Department of Primary Industries

OUT17/18978

**United Wambo Open Cut Coal Project (SSD 7142, DA 305-7-2003 MOD 16, DA 177-8-2004 MOD 3)
Comment on the Response to Submissions (RTS)**

Figure 5-3: Registered Groundwater Bores Within Four Kilometres of the Project Area

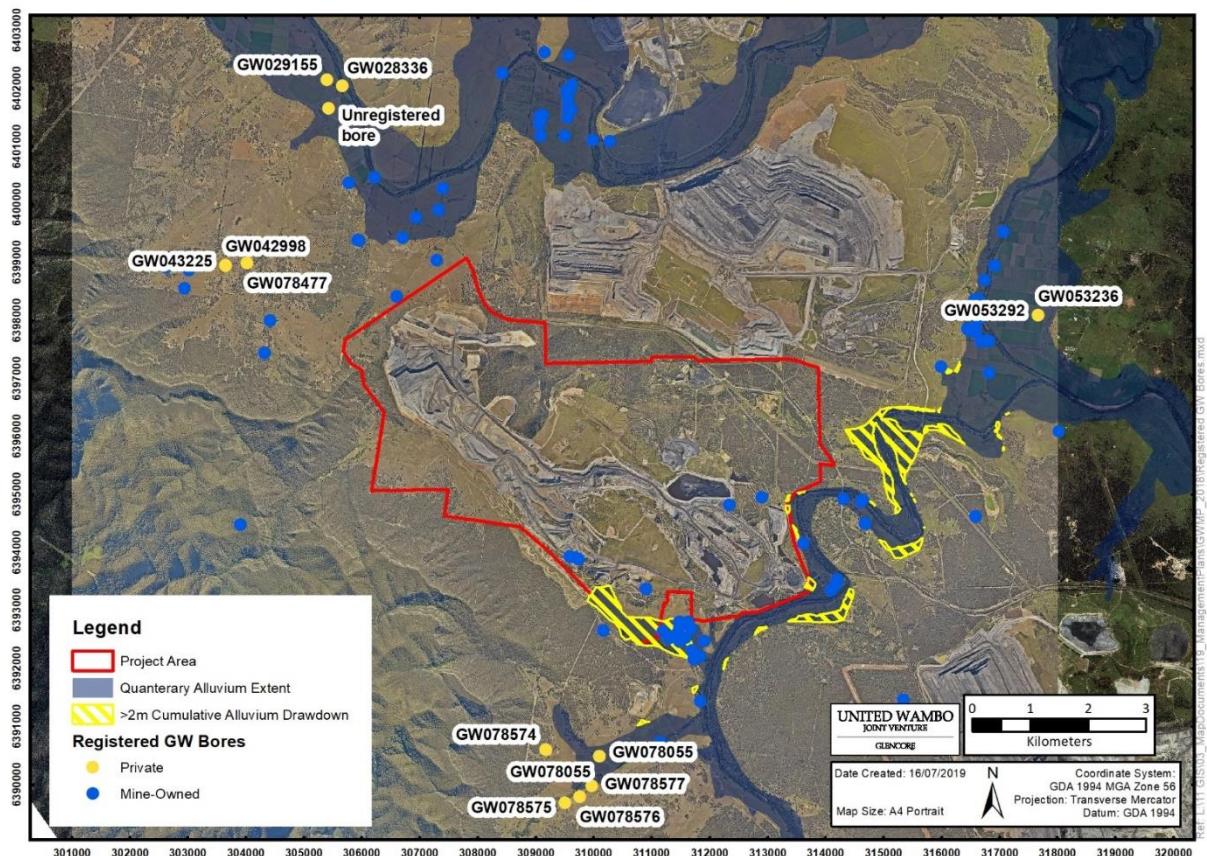
- The proponent has committed to carry out a plan to monitor private water bore GW060780 which may potentially be impacted by the project. The proponent should commence undertaking periodic assessments for all private bores within the predicted affected zone for the project in order to establish baseline information to use as a performance measure in the Trigger Action Response Plan.

- The proponent should advise whether GW060750 is still used for stock and domestic purposes. This work is currently owned by Coal & Allied however this property may still be used for agricultural purpose and predicted drawdown is 4.3 m with the bore log showing a thin sandstone water bearing zone.
